From: [REDACTED]
Sent: [REDACTED]
Cc: Sian Eggington
Subject: 17-111.1 EP/108/19/HH
Attachments: We sent you safe versions of your files; 17-111.1 Loc.pdf
Categories: Green Category

“Two storey front, two storey side and two storey rear extension and additional parking bay to garage.”

Block Plan 1:500

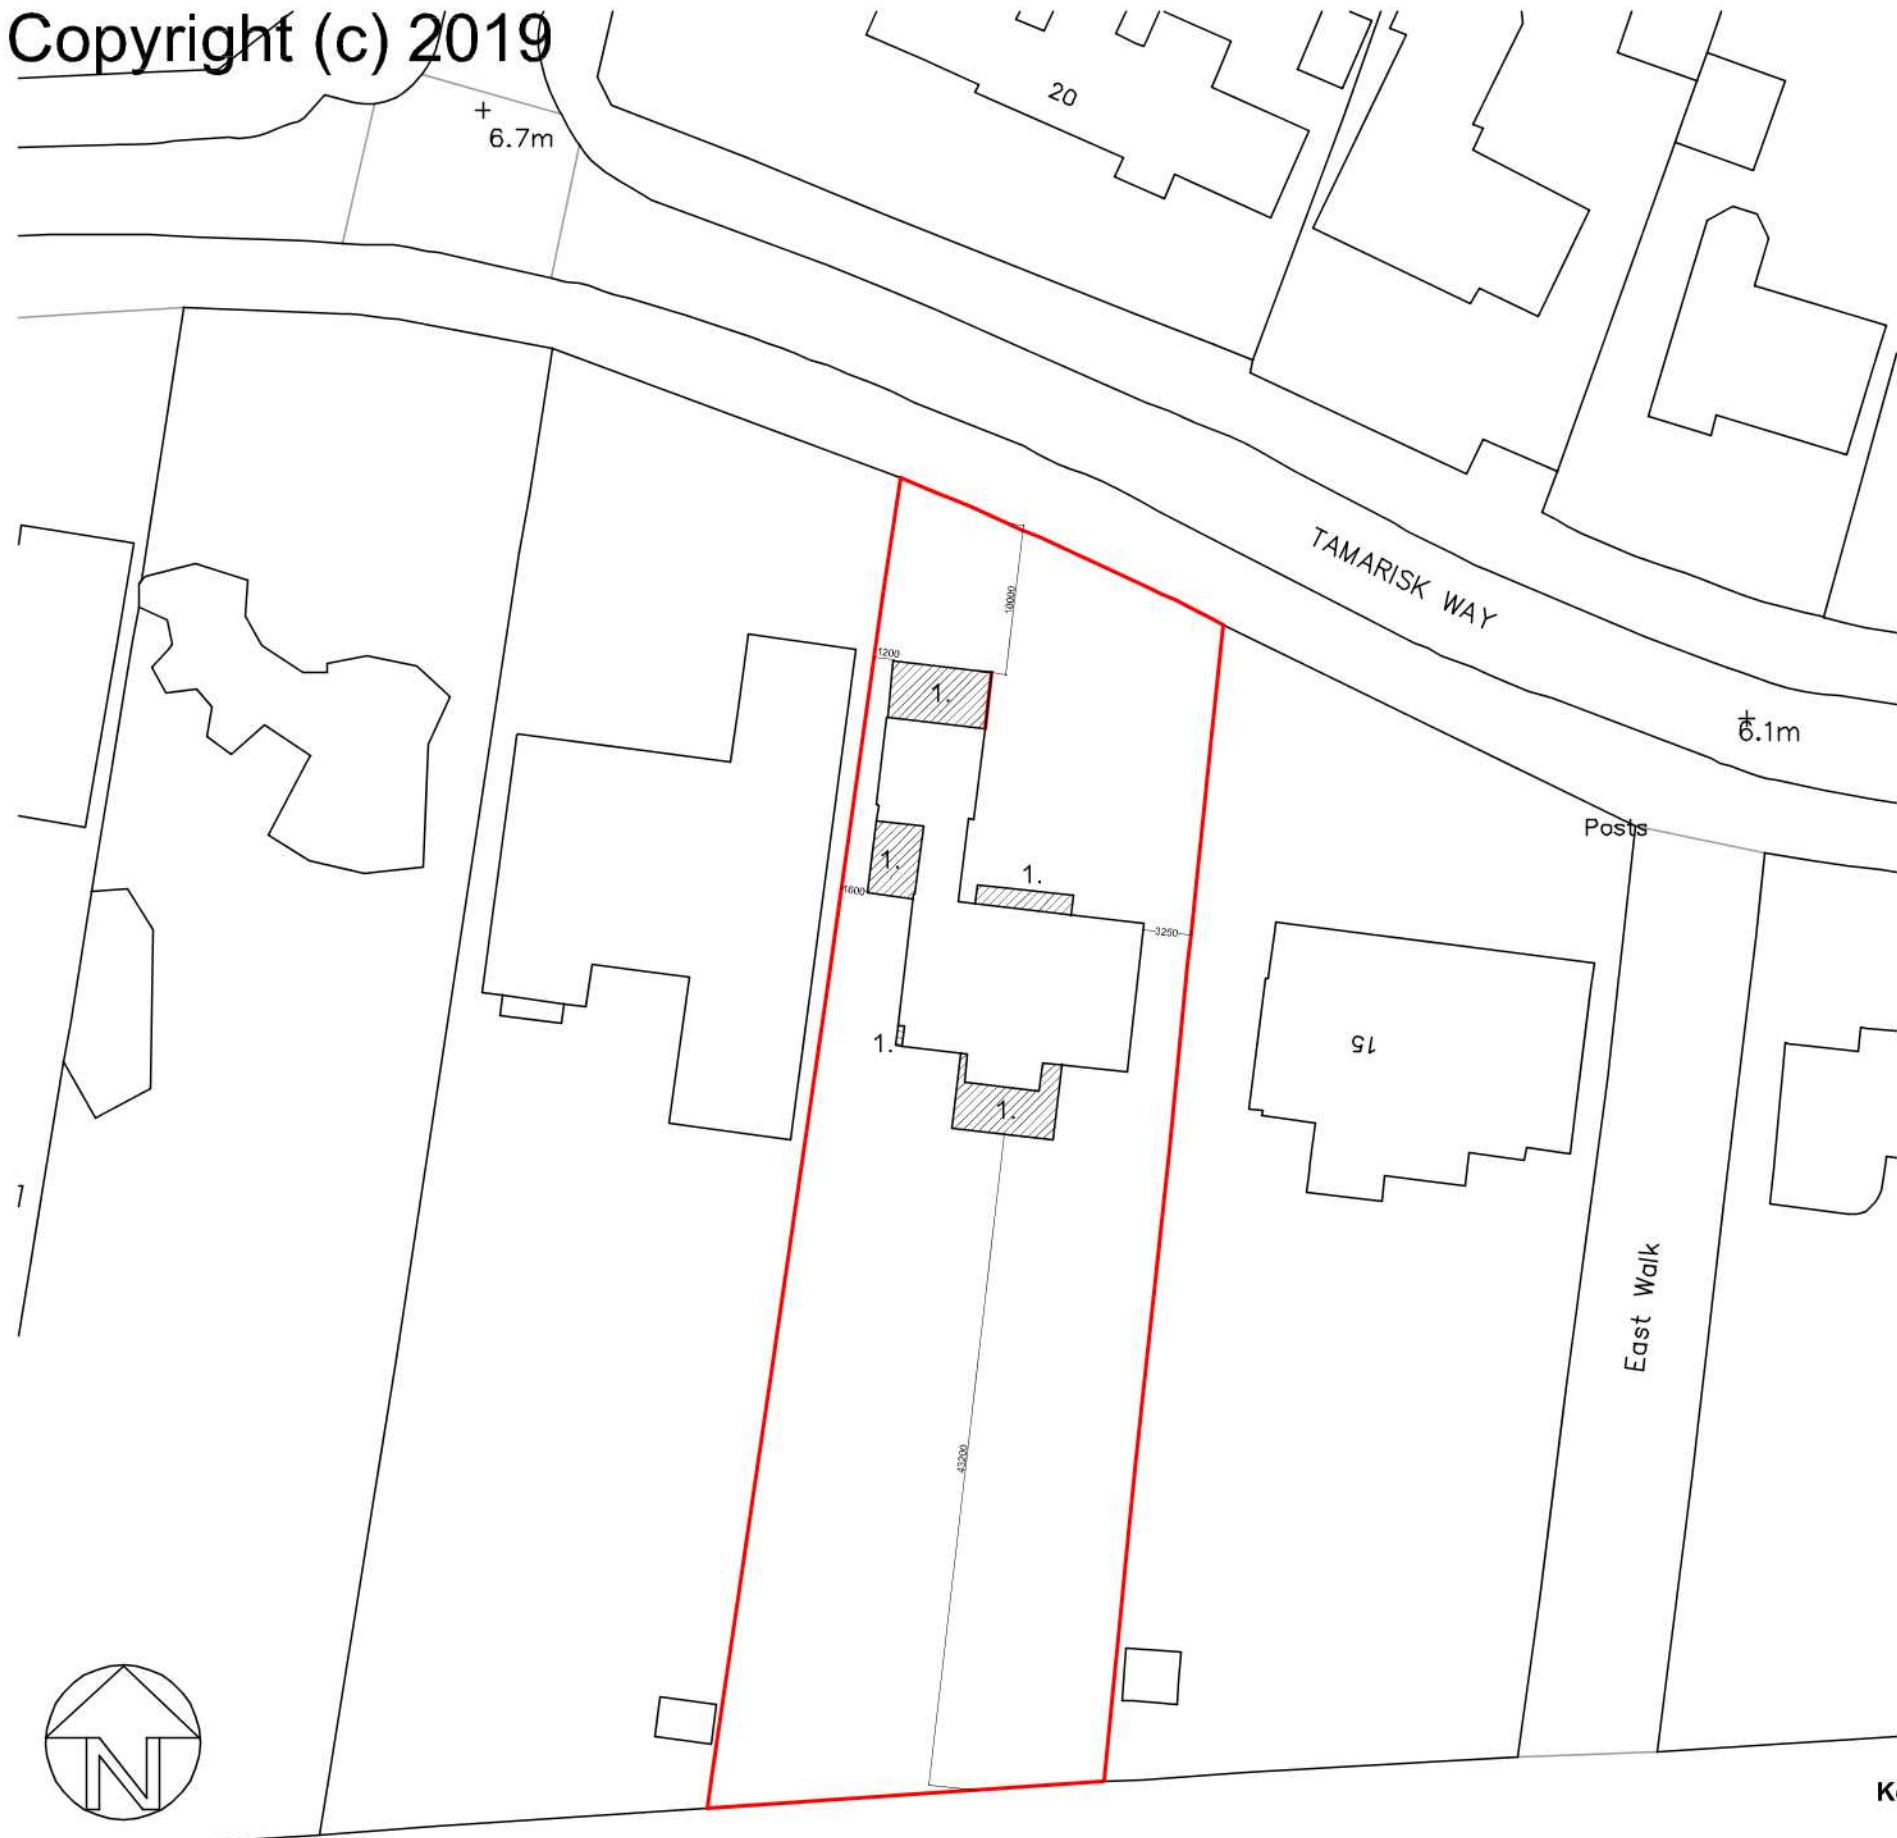
ii) Block Plan

You are required to include dimensions on the block plan from the proposed extensions to all site boundaries.

Please find attached amended block plan
